Please ask for: Mrs D Johnson
Email: daun.johnson@arun.gov.uk
Telephone: 01903 737762
Our Ref: BR/73/22/PL
Your Ref:
Date: 4th April 2022

Application for Planning Permission

Development: Installation of bicycle and refuse/recycling store within rear garden, install window at end of eastern side retain, replace windows to west and east side elevations and install glazed French doors and windows to southern rear elevation. This application is in CIL Zone 4 (Zero Rated) as other development.

Location: 83 Aldwick Road Bognor Regis PO21 2NW

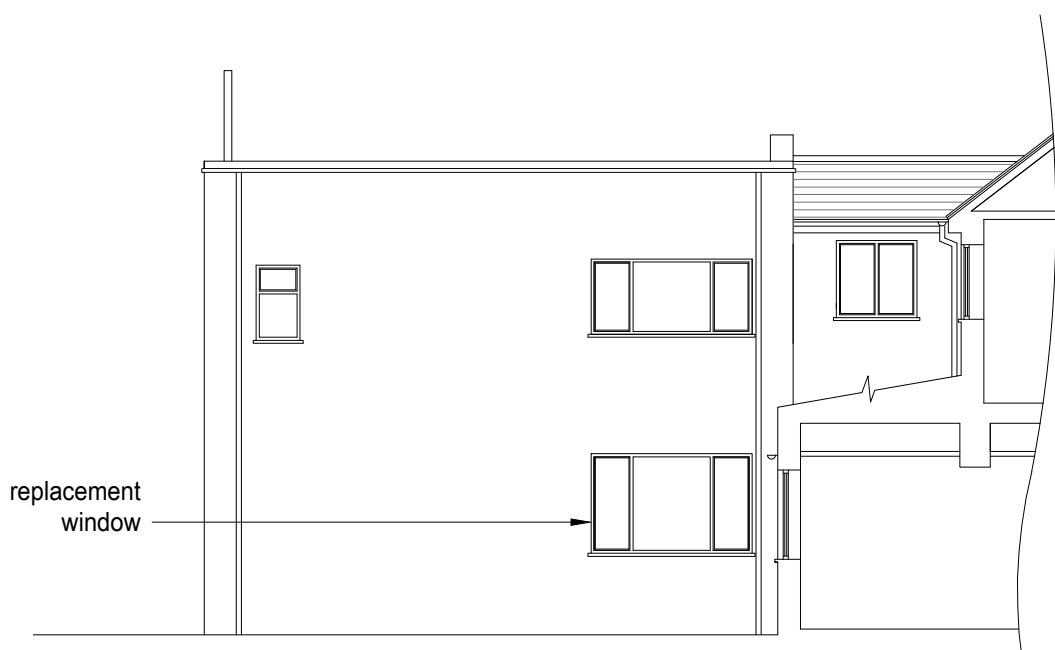
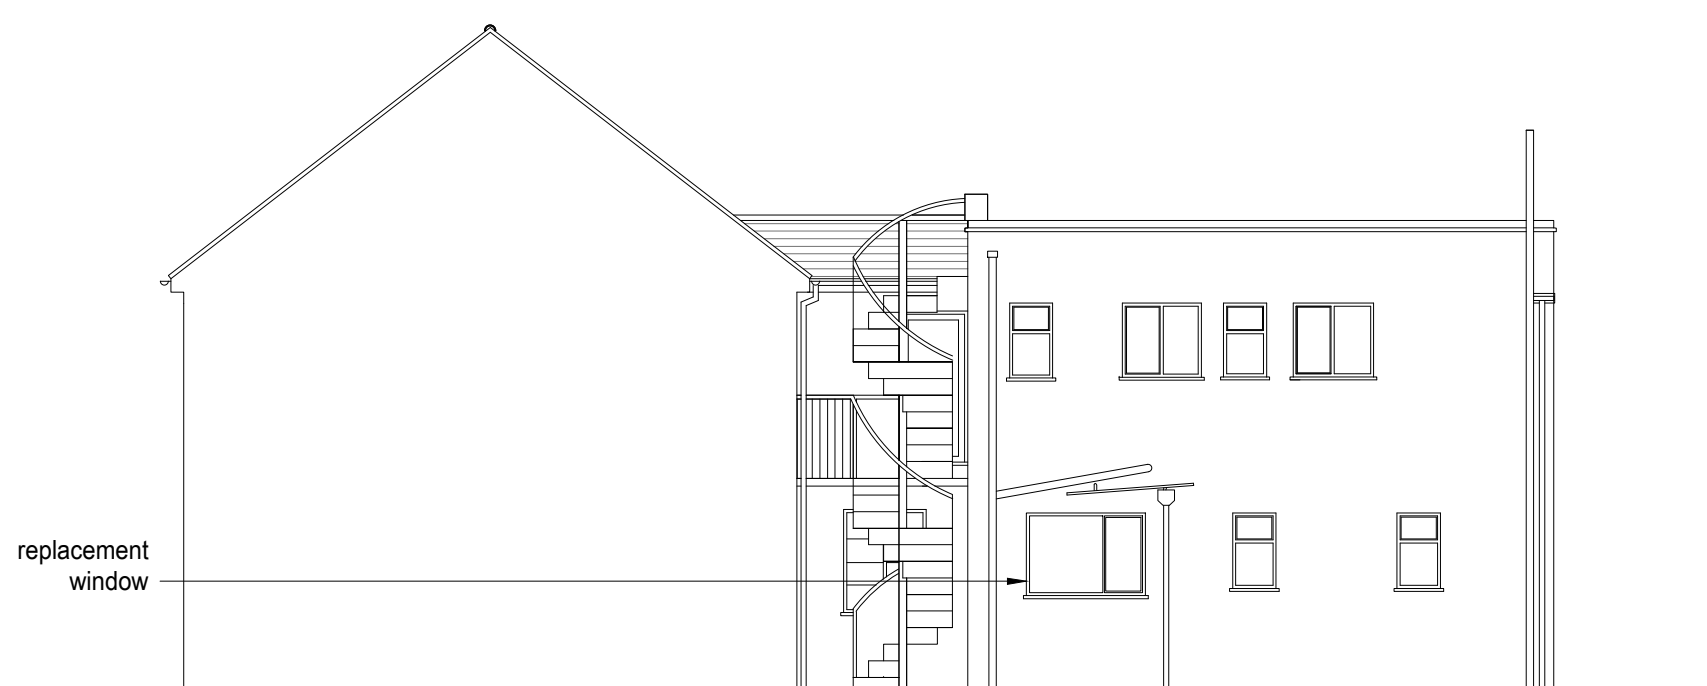
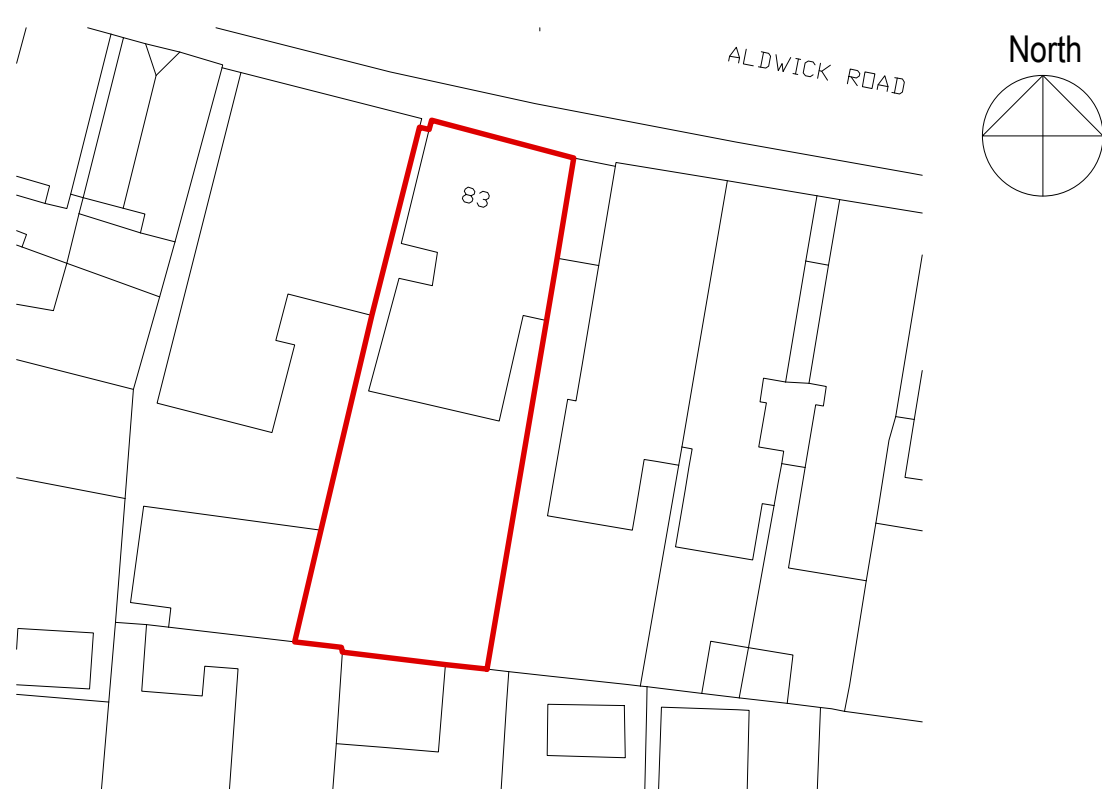
The legend for Plan states Proposed ground floor and second floor plan, however, there is not a proposed second floor plan on the plan. Please clarify.

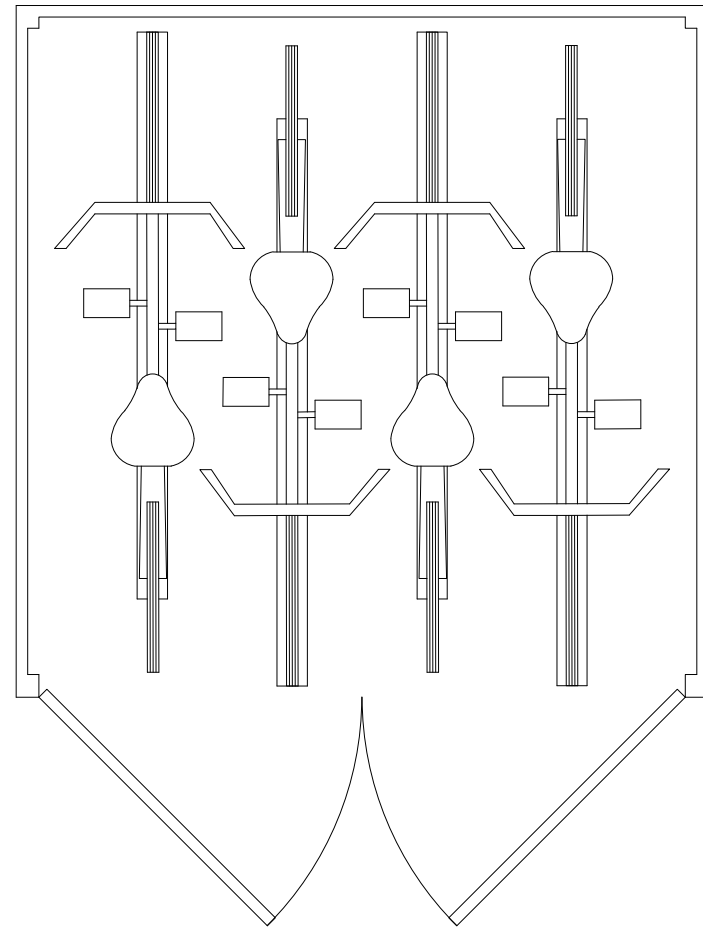
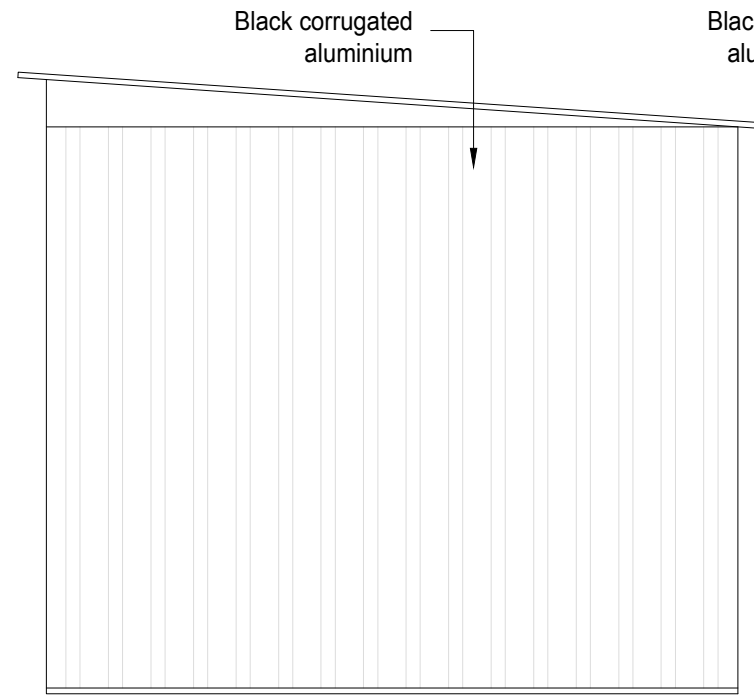
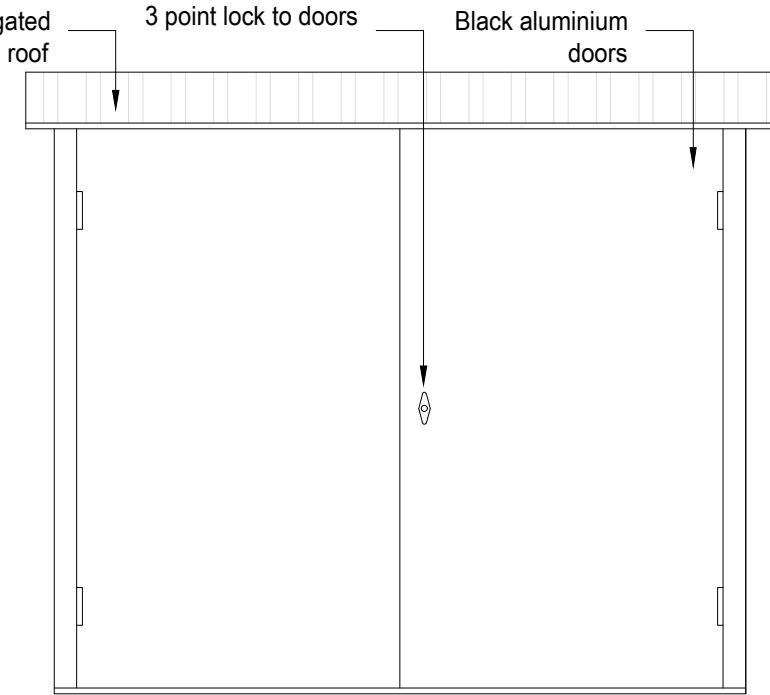
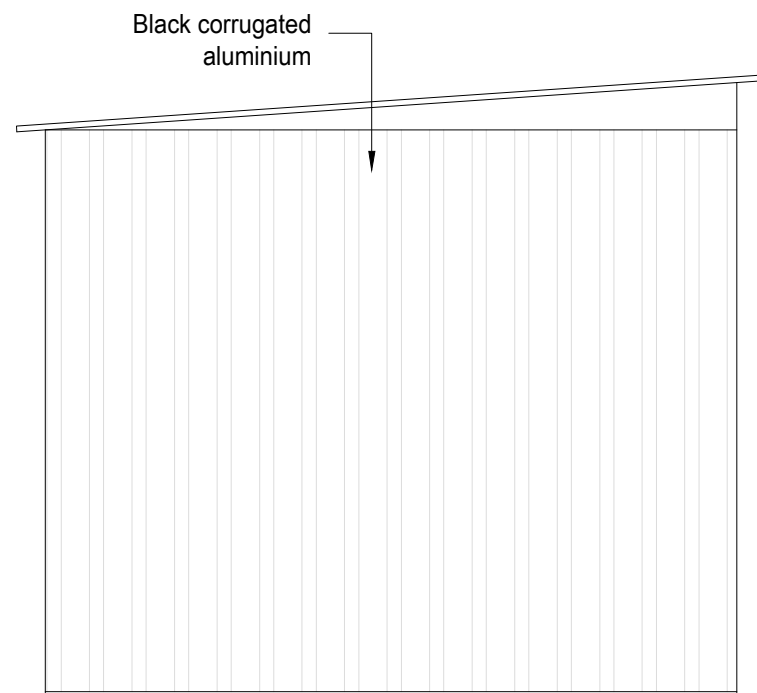
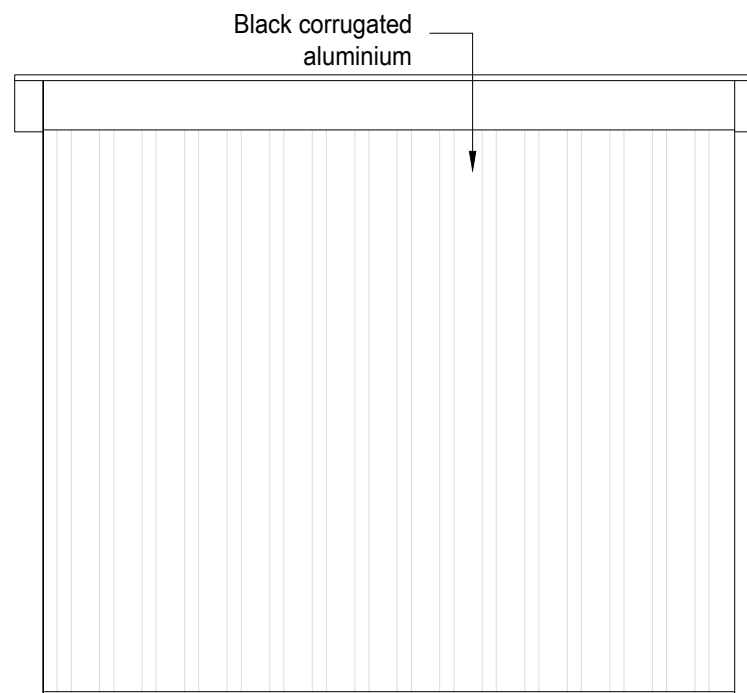
Please provide proposed elevations for the bicycle and refuse/recycling store.
